STATEMENT TO SUPPORT THE HOUSEHOLDER PLANNING APPLICATION RESUBMISSION 10 MANOR ROAD, WHALLEY, LANCASHIRE

Following the refusal of the previous application this statement is written to highlight the amendments to the proposal which aim to resolve the reasons for the decision.

3 PROPOSED SOUTH  
1 : 50

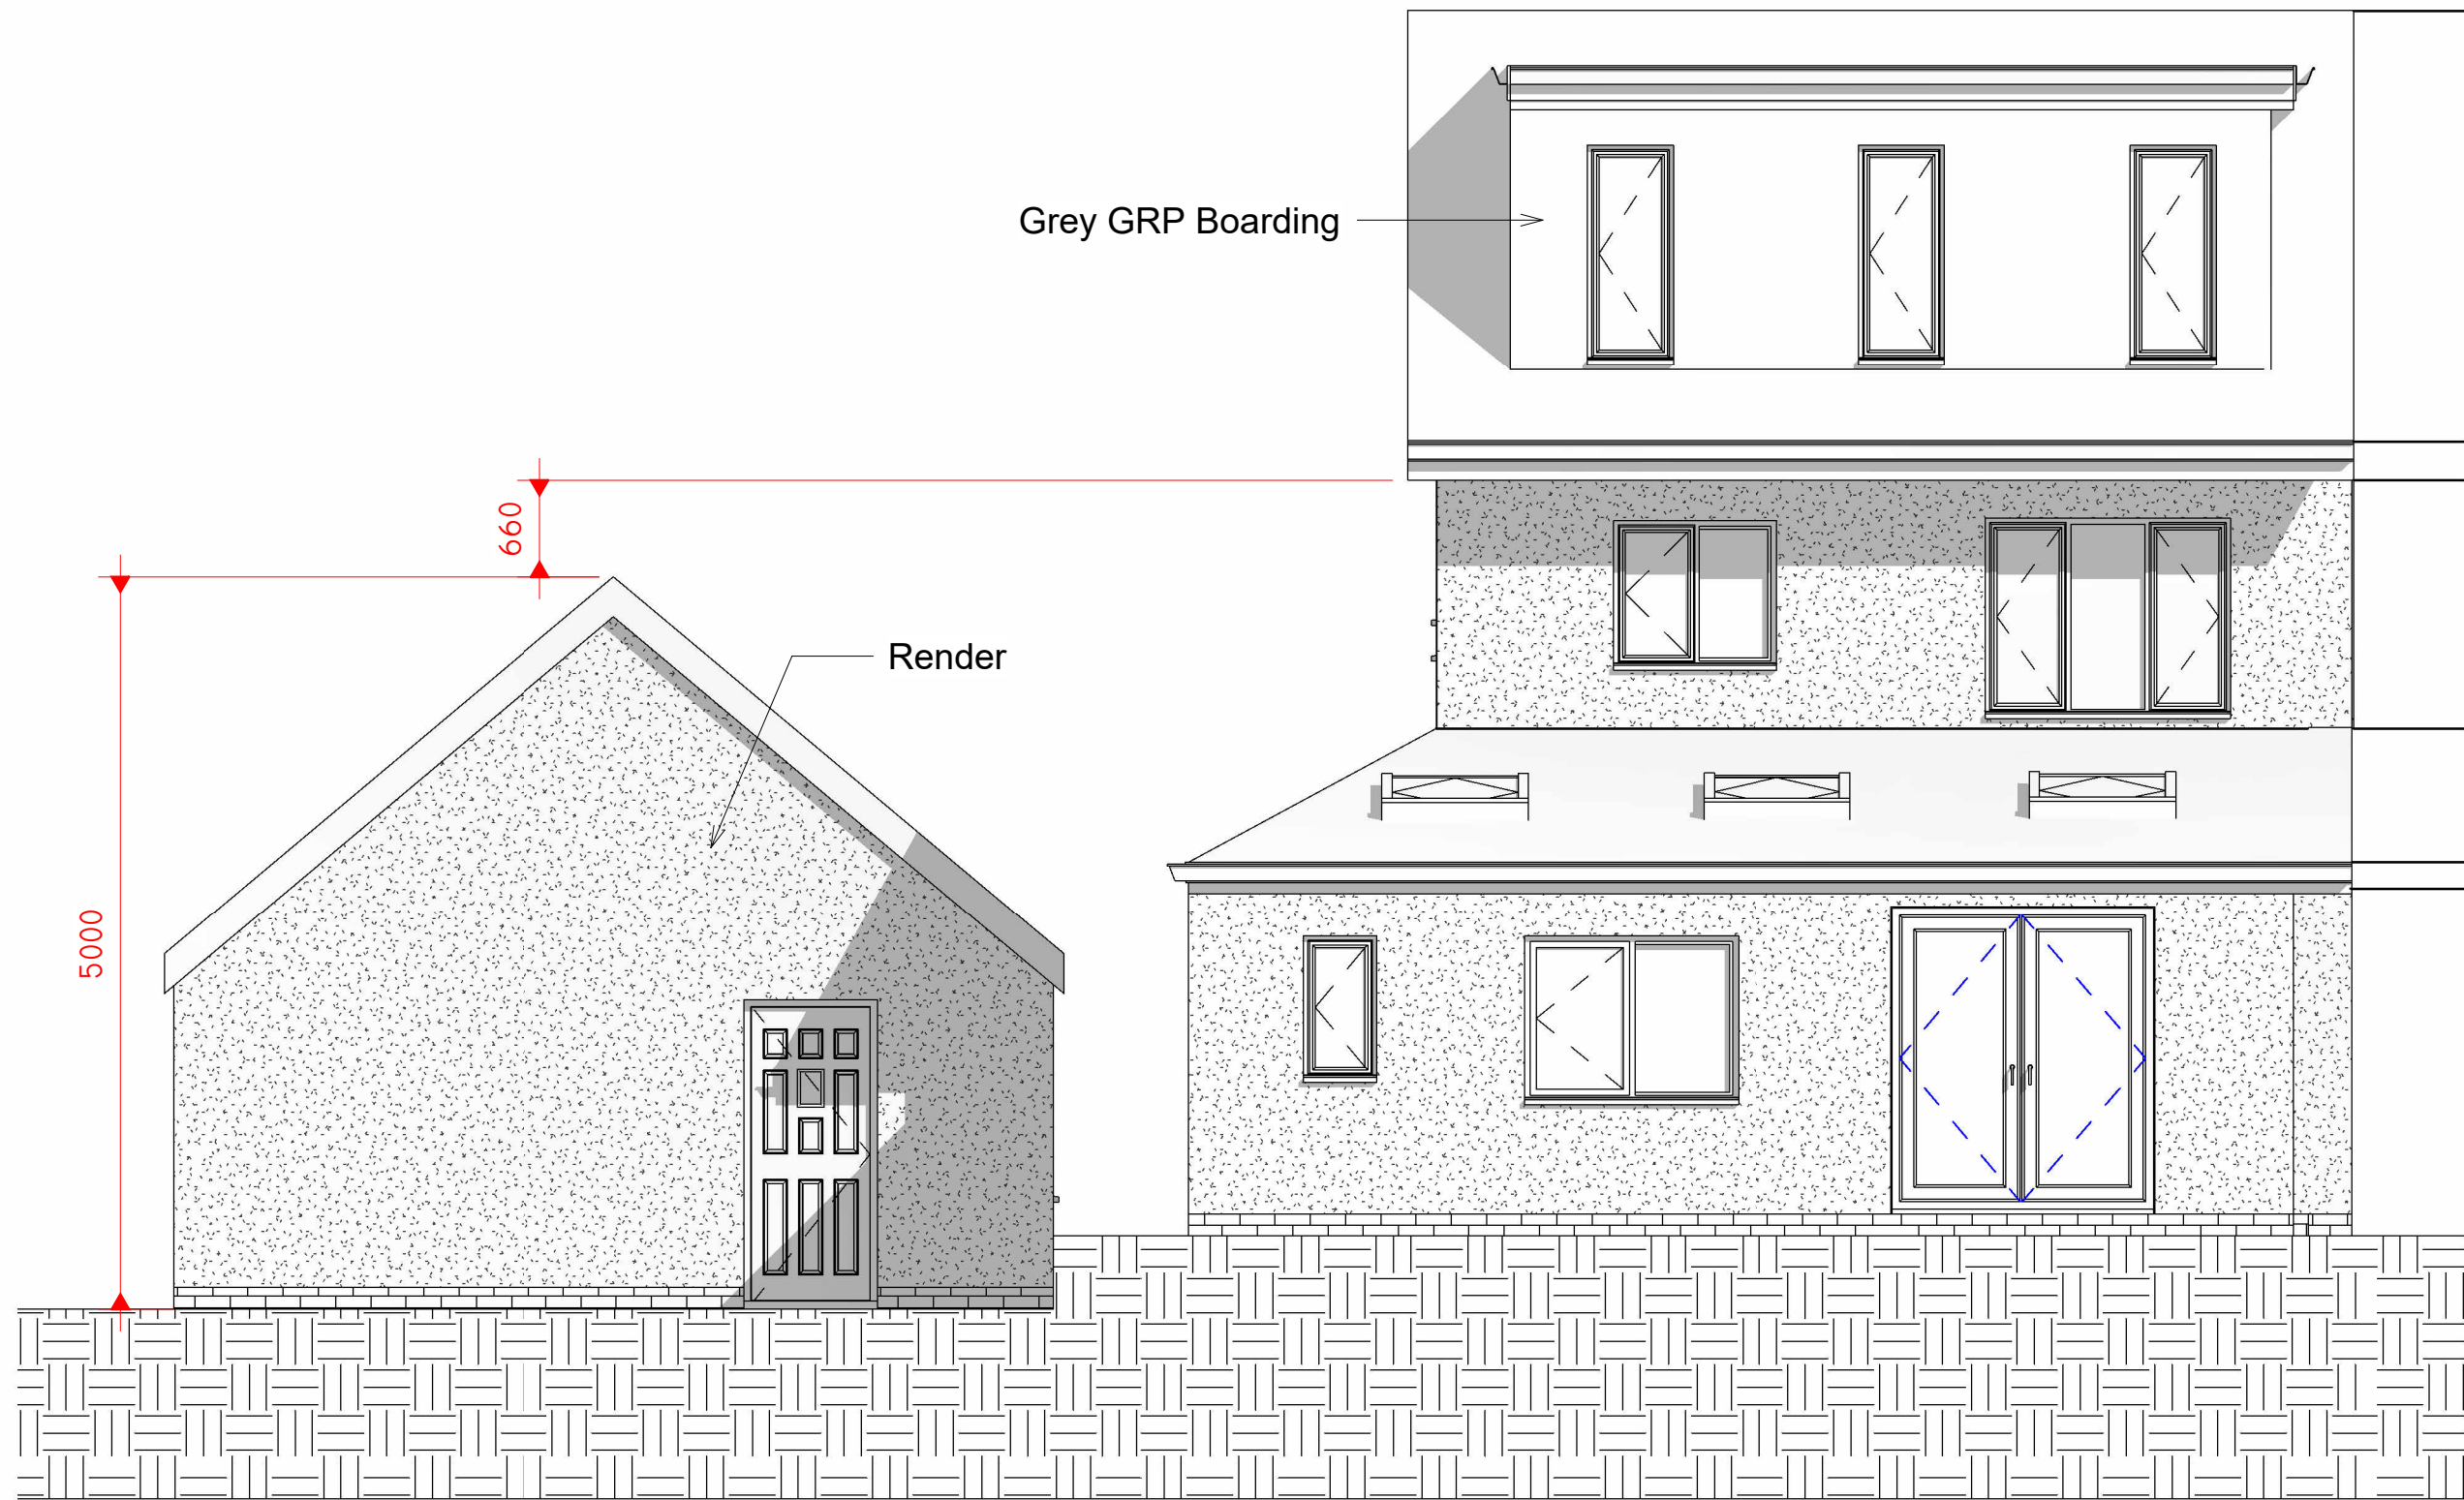
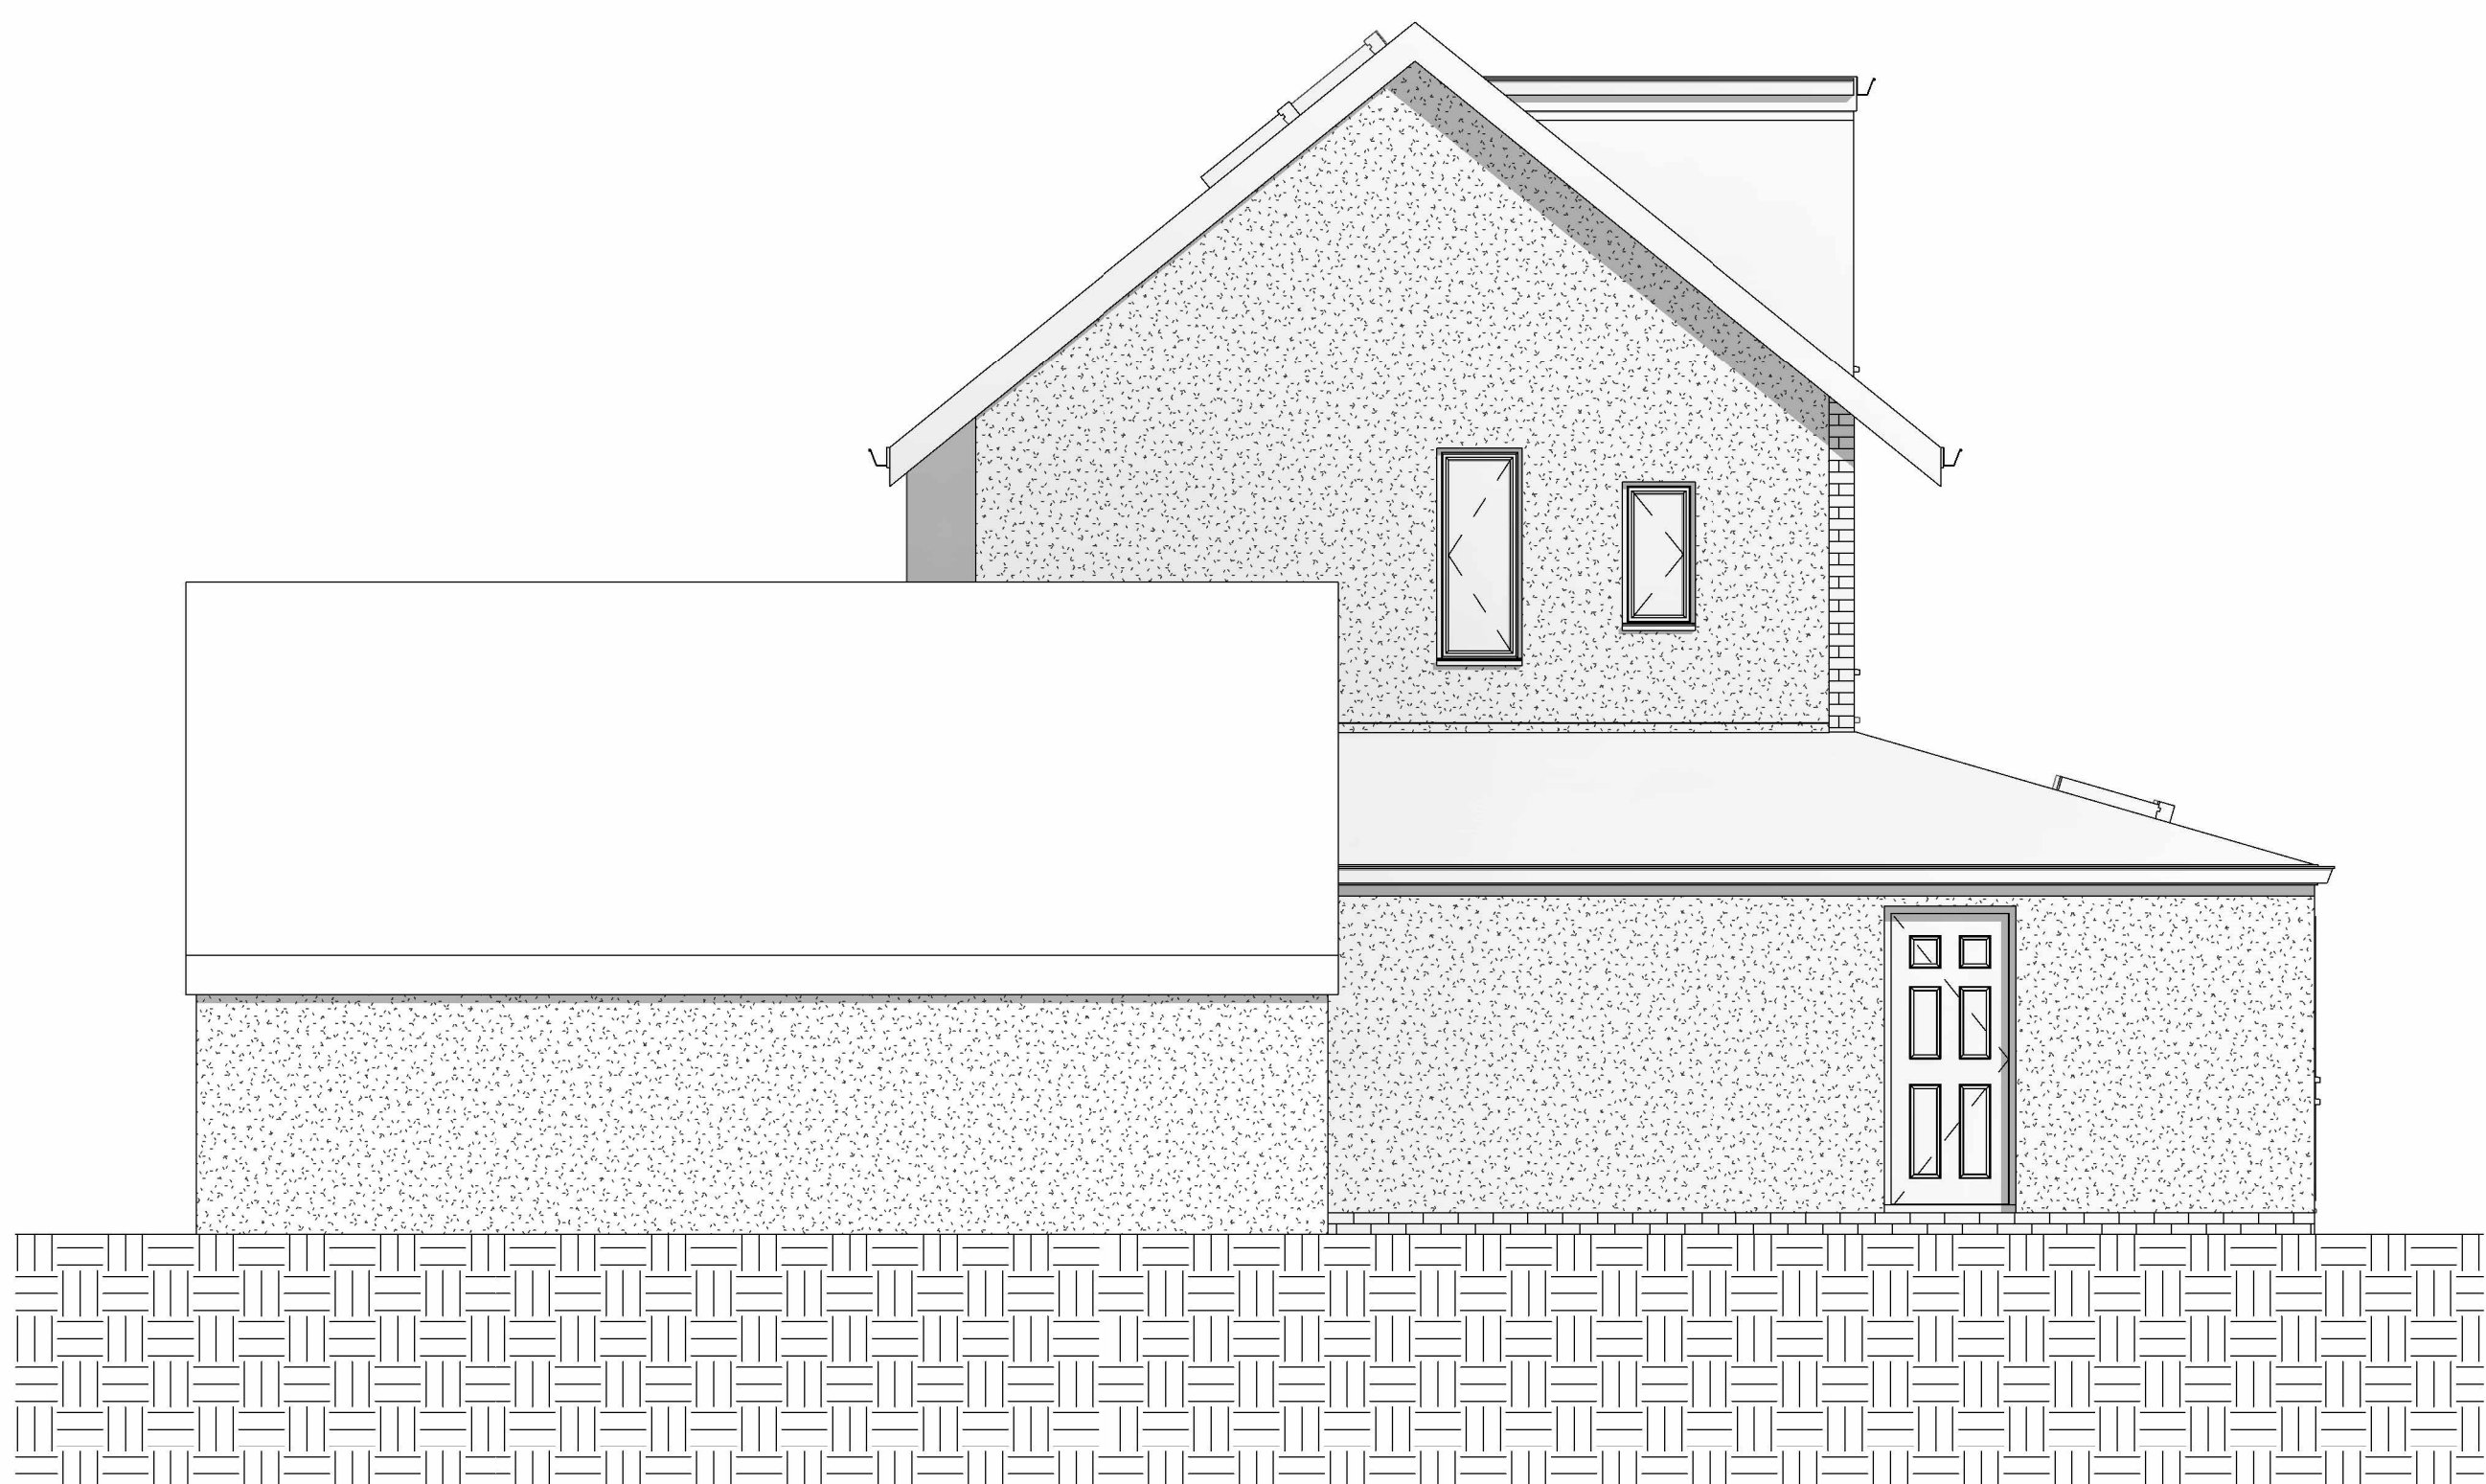
In this instance, the proposal involves the addition of a two storey garage structure which would stand at just over 5 metres in height meaning the roof ridge of the garage would be sited above the eaves of the host property. In addition, the garage's footprint would be offset to the footprint of the main dwelling therefore the proposed garage would be disruptive to the symmetry currently shared between the property and the existing detached garage.

Furthermore, the replacement single storey wrap around extension would incorporate a flat roof design which would be largely at odds with the pitched roof design recently installed on the property. In addition, the incorporation of large glazed openings and composite timber boarding to the front elevation of the proposed extension and the entire first floor level of the property would be entirely at odds with the brick and pebble dashed render elevations and casement style windows installed on neighbouring properties within the immediate locality.

Moreover, all of the above works and alterations would be read in concert with the largely unsympathetic hipped to gable roof conversion and rear dormer currently under construction at the property. It is proposed to clad the rear dormer in a standing seam zinc finish which would introduce another different material and finish, further exacerbating the visual impact.

As such, the cumulative visual impact of the two storey garage, single storey wrap around extension, reconfigured window fenestration and installation of composite timber boarding and zinc cladding would collectively read as an over bearing and unsympathetic modification of the host property, with the proposed works and previously approved works reading as a significant over development of the application site. Furthermore, all of the application property's elevations are viewable within the public realm therefore the visual impact of the proposed development would be pronounced.

The garage ridge height is 5m and 0.5m below the eaves of the host dwelling. The footprint remains as existing as the garage is to be redeveloped with a loft space. The eaves is raised 0.3m and the existing brick facings are shown as fully rendered. The roof has been re-designed as a gabled arrangement which matches the appearance of the house which has been reconstructed recently from a hipped arrangement to a gable end property.

The wrap around (replacement) extension now incorporates a mono pitch (hipped) roof design. The walls are fully rendered with a brick plinth and the glazing proportions amended.

The rear dormer is shown as clad with a grey composite boarding to blend with the concrete roof tiles of the main roof. This minimises any visual impact and is a more sympathetic solution.

The revisions demonstrate that the cumulative impact has been significantly reduced by virtue of retaining the garage in it's existing position and redeveloping the structure. The removal of timber boarding to the elevations to be replaced with a render finish and the continuation of a pitched and hipped mono pitch wrap around to the house at ground floor support this.
